**Subject:** LU/125/20/L

## LU/125/20/L

*Listed Building consent for removal & replacement of existing failed concrete ceiling of basement boiler room/floor of the WCs, replacement & reconfiguration of existing WC's. This application affects the character and appearance of the East Street, Littlehampton Conservation area.*

WSAPC Littlehampton - Proposed WC Internal Elevations

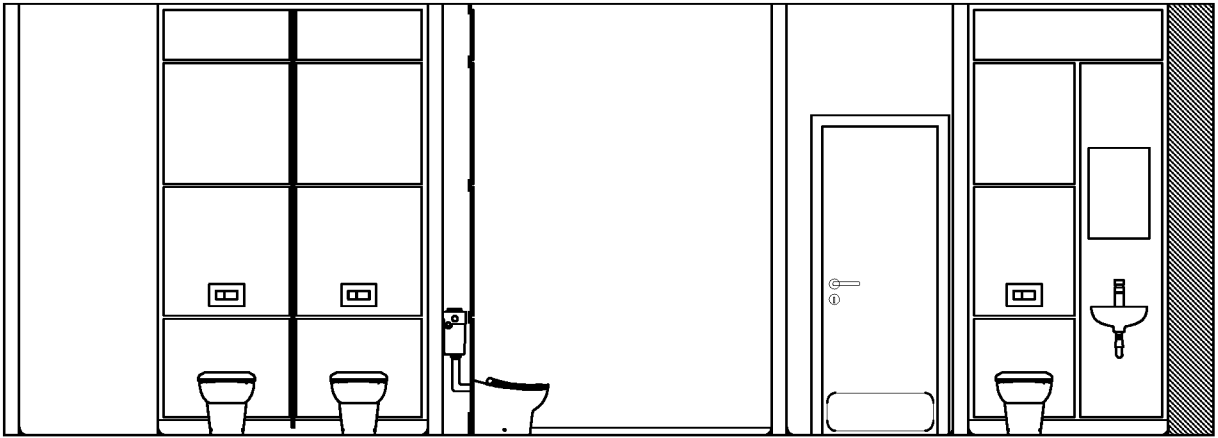
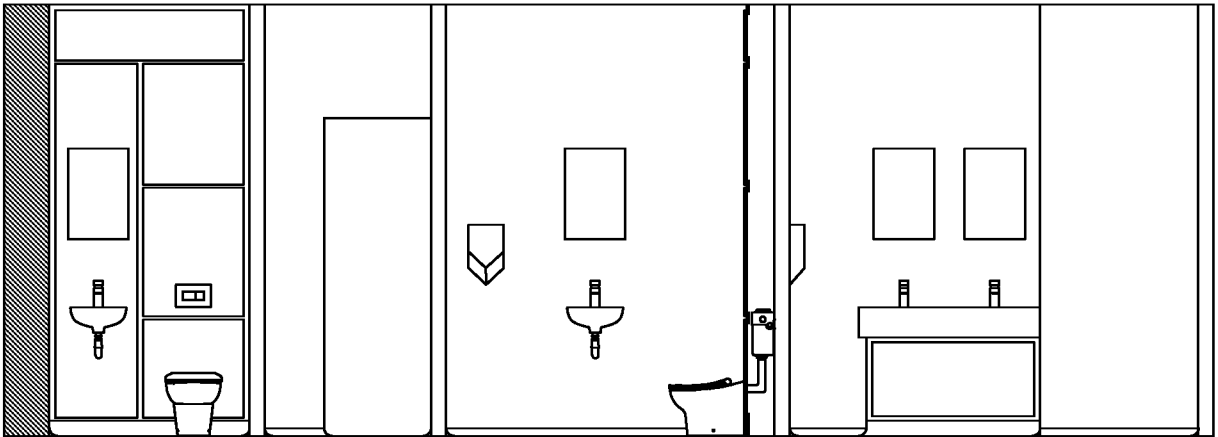
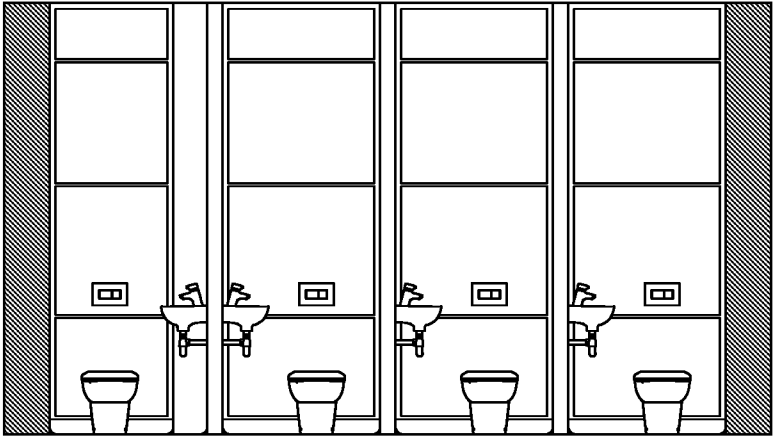
In general, it is considered that the proposed works will have a neutral impact upon the significance of the building. I only have one area of concern, that of one of the new partition walls in the Wc's. The dividing partition between cubicles DG07 and DG08 is unfortunate as it will be constructed from concrete blocks and would impact upon the existing window configuration. Are there any alternative options for this element of the proposal?
